Consultation Response from KC, Conservation and Design**2020/94070 69-71, Cowlersley Lane, Cowlersley, Huddersfield, HD4 5UE****Use of premises for self-service launderette facility and associated works****Date Responded: 13.1.21 Responding Officer: Sue Oakley Responding Ref:**

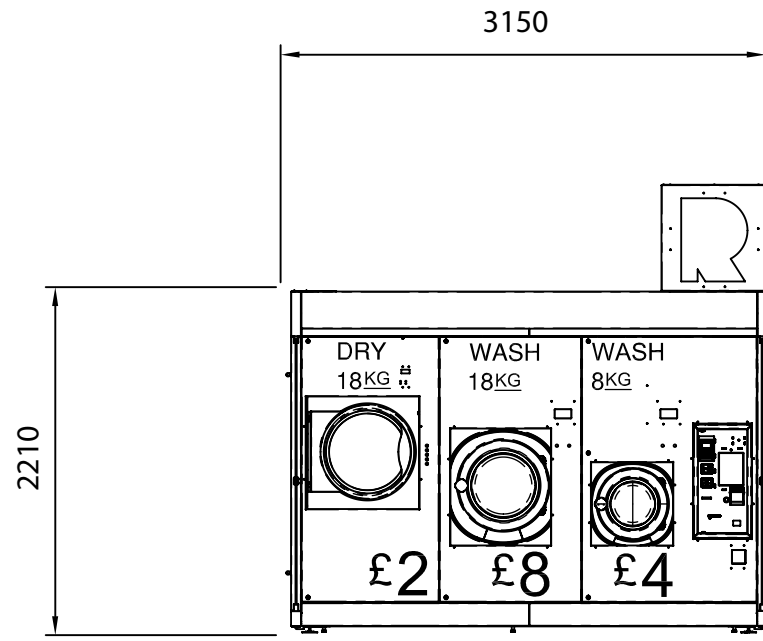
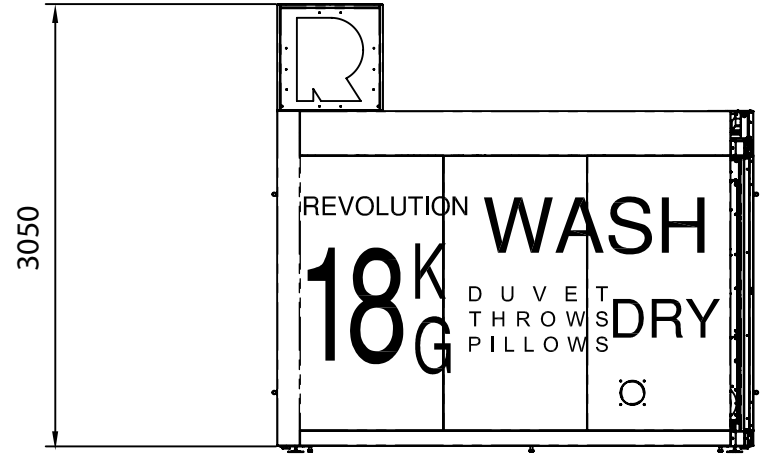
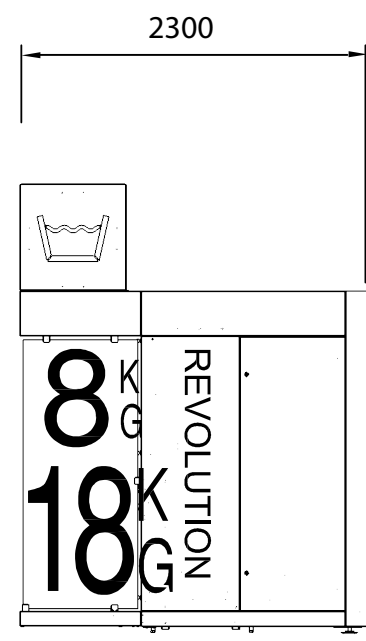
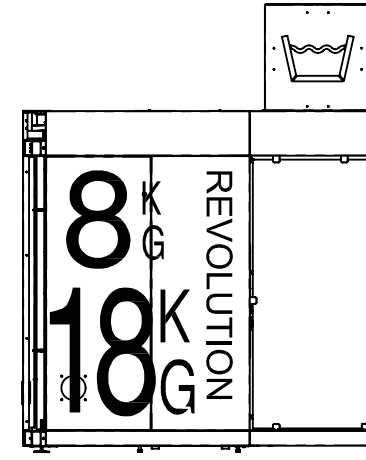
The launderette facility (retrospective application) is a large steel unit located to the front of the business, out of character with the local vernacular and visible along Cowlersley Lane, which is considered to lead to slight harm to the setting of the listed cottages by the introduction of a large steel unit within a predominantly stone built street.

The Conservation and Design Team consider that the slight public benefits of providing this facility outweigh the slight harm, and if this proposal is supported would request that it is well maintained and if it becomes redundant is removed from site.
